Application for Removal or Variation of a Condition following Grant of Planning Permission or Listed Building Consent

LISTED BUILDING CONSENT FOR DEMOLITION OF EXISTING CONSERVATORY, AND ERECTION OF SINGLE STOREY EXTENSION, NEW REAR ENTRANCE CANOPY, REPLACEMENT WINDOWS AND DOOR AND REINTRODUCTION OF MULLIONS AND CHIMNEY, MINOR EXTERNAL MODIFICATION AND INTERNAL MODIFICATIONS OF MODERN PARTITIONS

2023/65/91257/W

| 3536 (0-1) 05                                                    |       | D          |

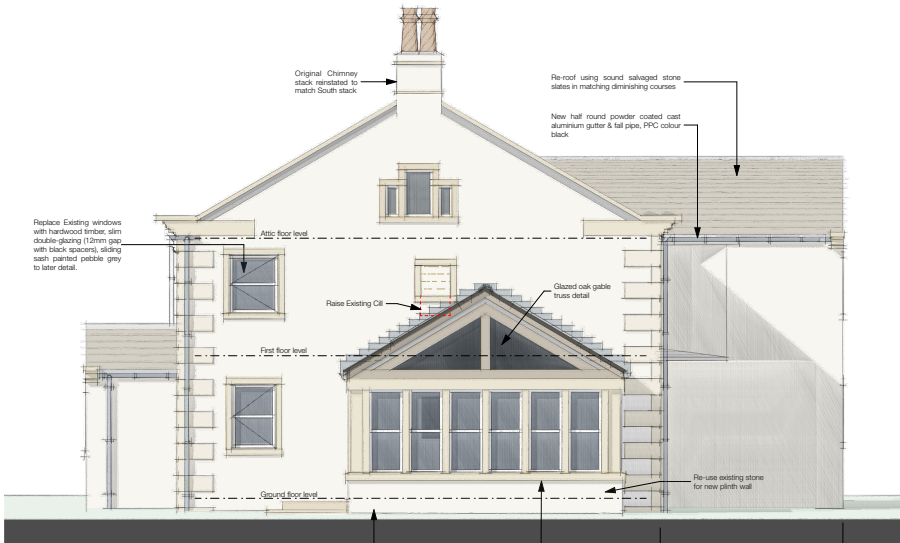
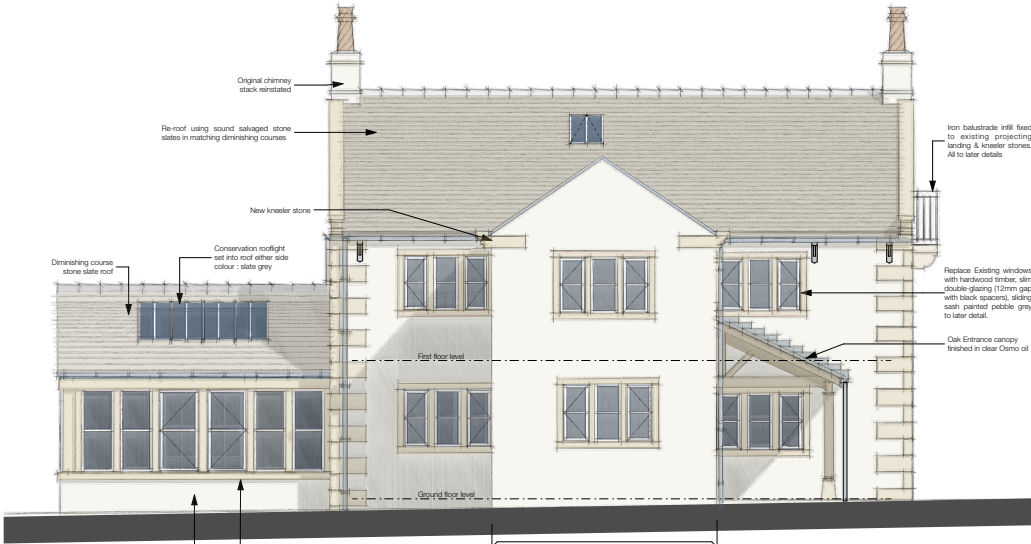
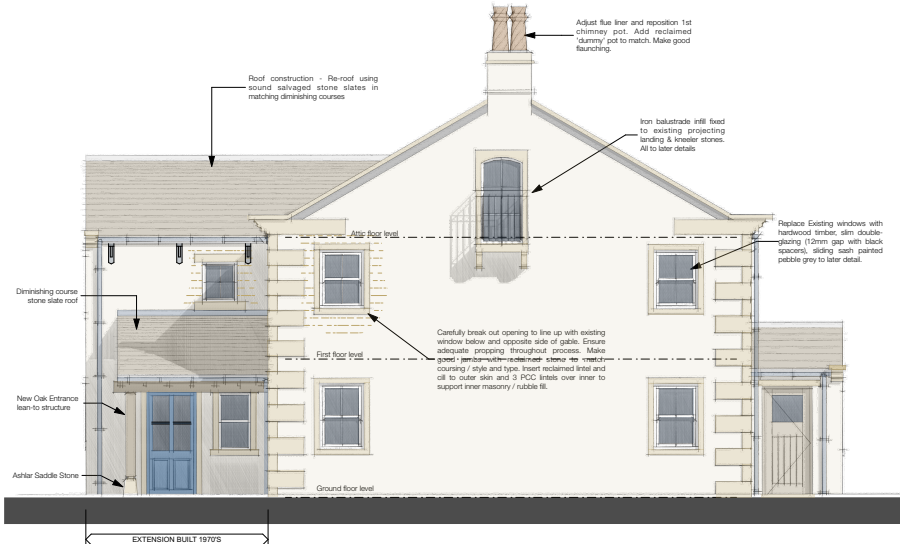
Condition 2 - we seek to vary the approved drawing referred to - elevation drawing 3536 (0-) 05 Rev C showed the majority of window openings as sliding sash. We would like to substitute the drawing with 3536 (0-) 05 Rev D. This incorporates the following amendment: Removal of stone finials. Reduction to sliding sash window to North and West elevation of the main house house and to the new conservatory. Replacing the sashes with a combination of fixed and casement windows with a horizontal glazing bar to replicate sliding sash windows as indicated on the revised elevations.
